Application No: AW/87/20/HH
Site Address: 2 Priory Close Aldwick West Sussex PO21 4HH
Description of works: Single storey front & rear extensions & detached outbuilding.

Thank you for your internet representation made on 6th May 2020 which has been recorded as an objection with the comments as follows:

PROPOSED SINGLE STOREY EXTENSIONS AT 2, PRIORY CLOSE, ALDWICK BAY
FOR MR. & MRS. A. MARTIN.

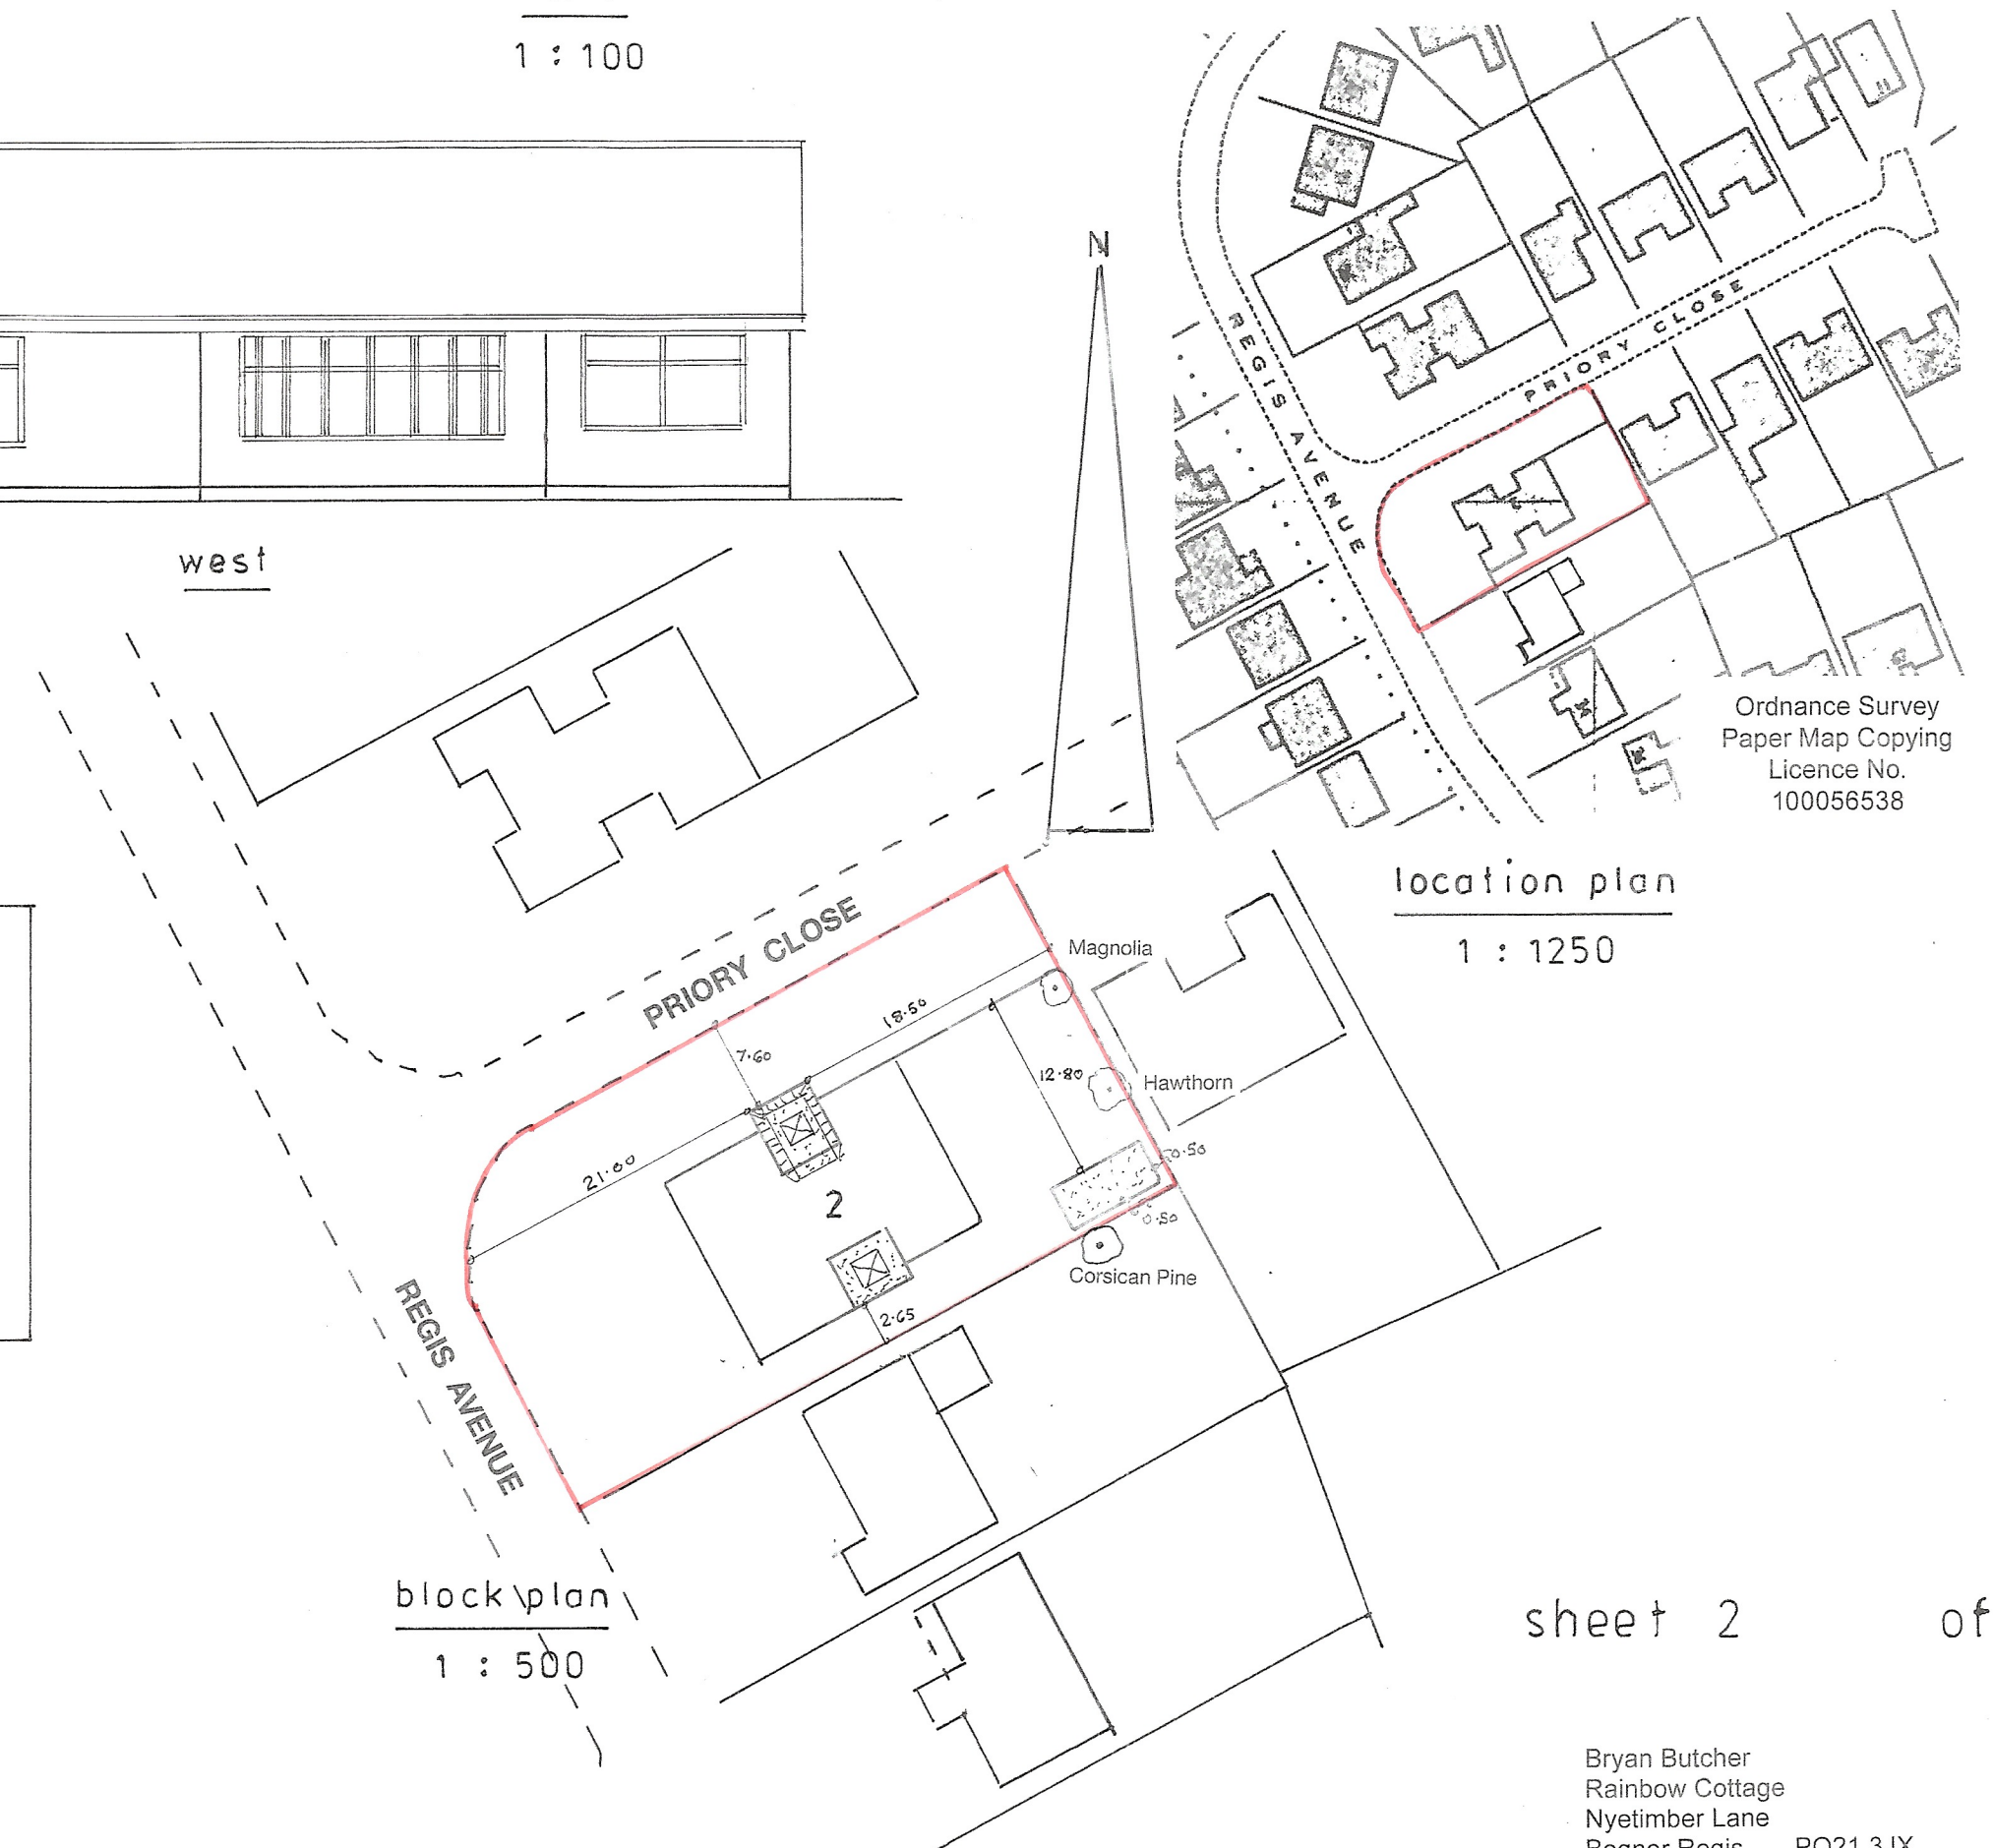
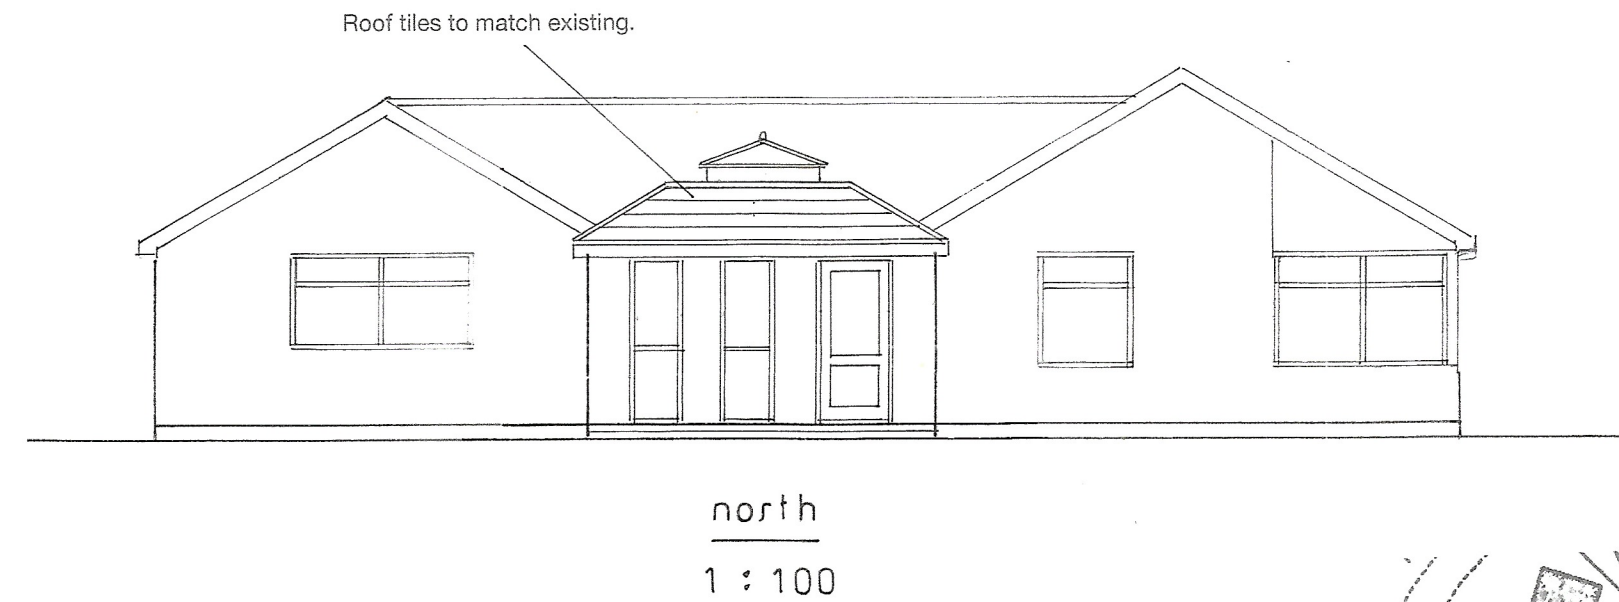
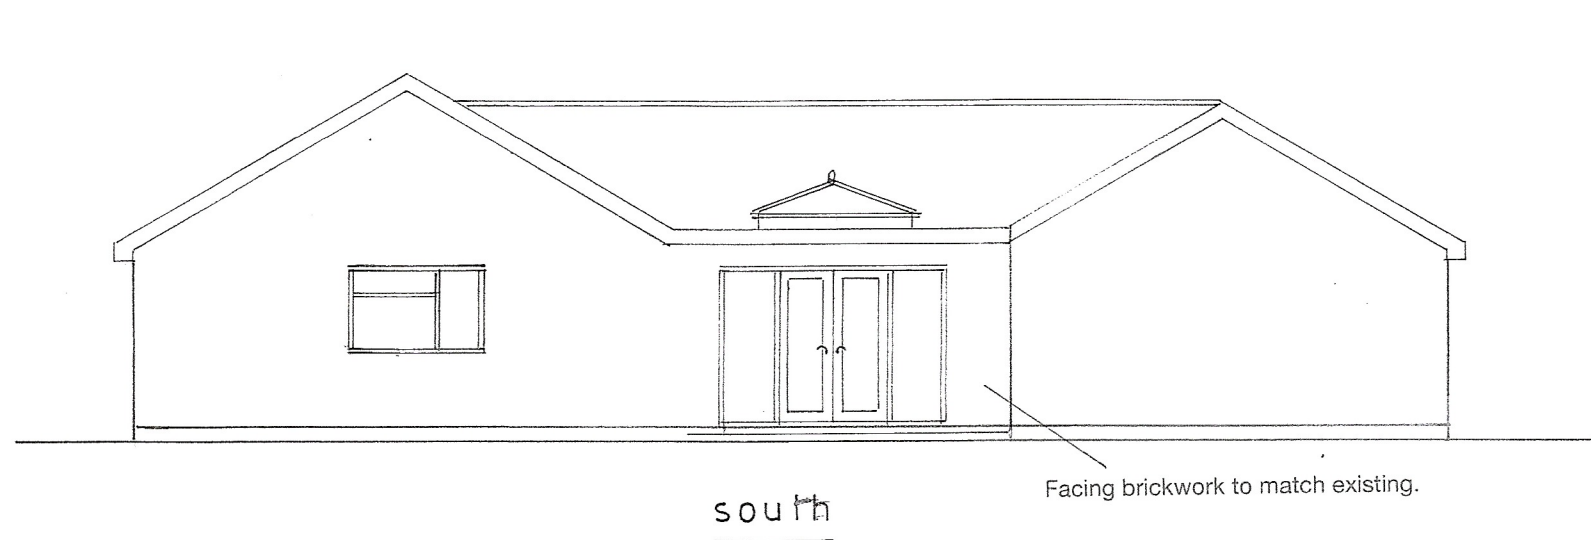
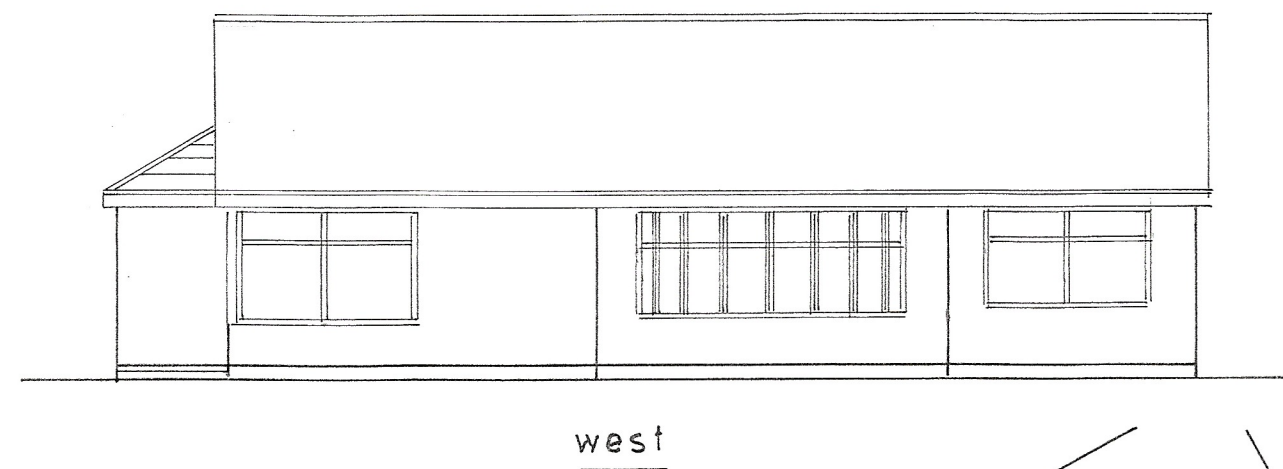
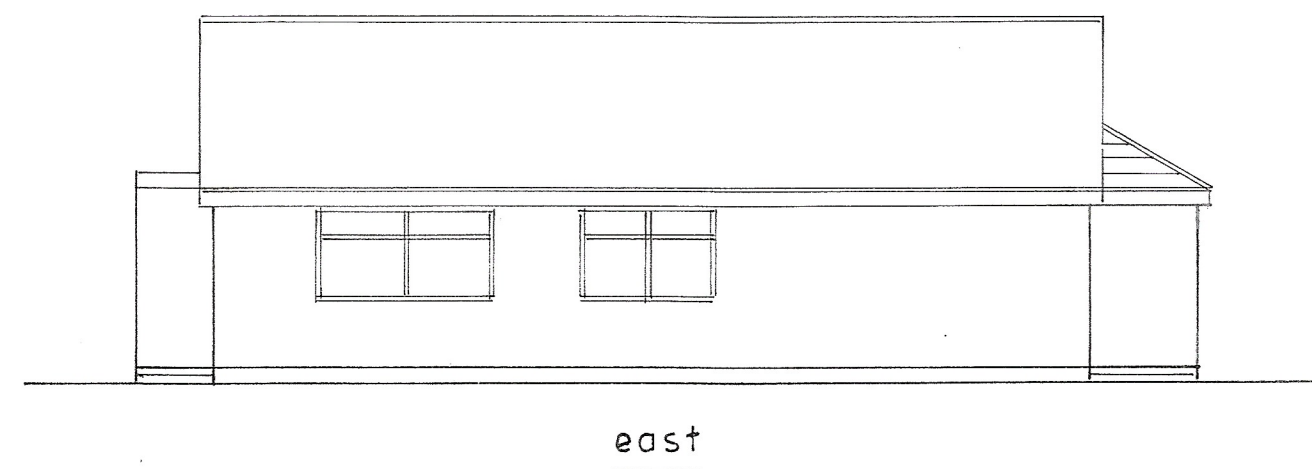
With regard to the proposed development to the south side of the applicant's dwelling, my wife and I are concerned that the outer limits of the development are too near to my property and that it will impinge on our day to day living. Our main ground floor living area has a window, 4m wide and is immediately adjacent to the proposed extension on the south side of the applicant's dwelling, which will be approximately 4m away from our window. The proposed flat roof will be unsightly from our living area. If this development is granted, it would look better with a pitched roofline feathered into the existing building, similar to that which is proposed on the north side of the dwelling, which will be more pleasing to the eye.
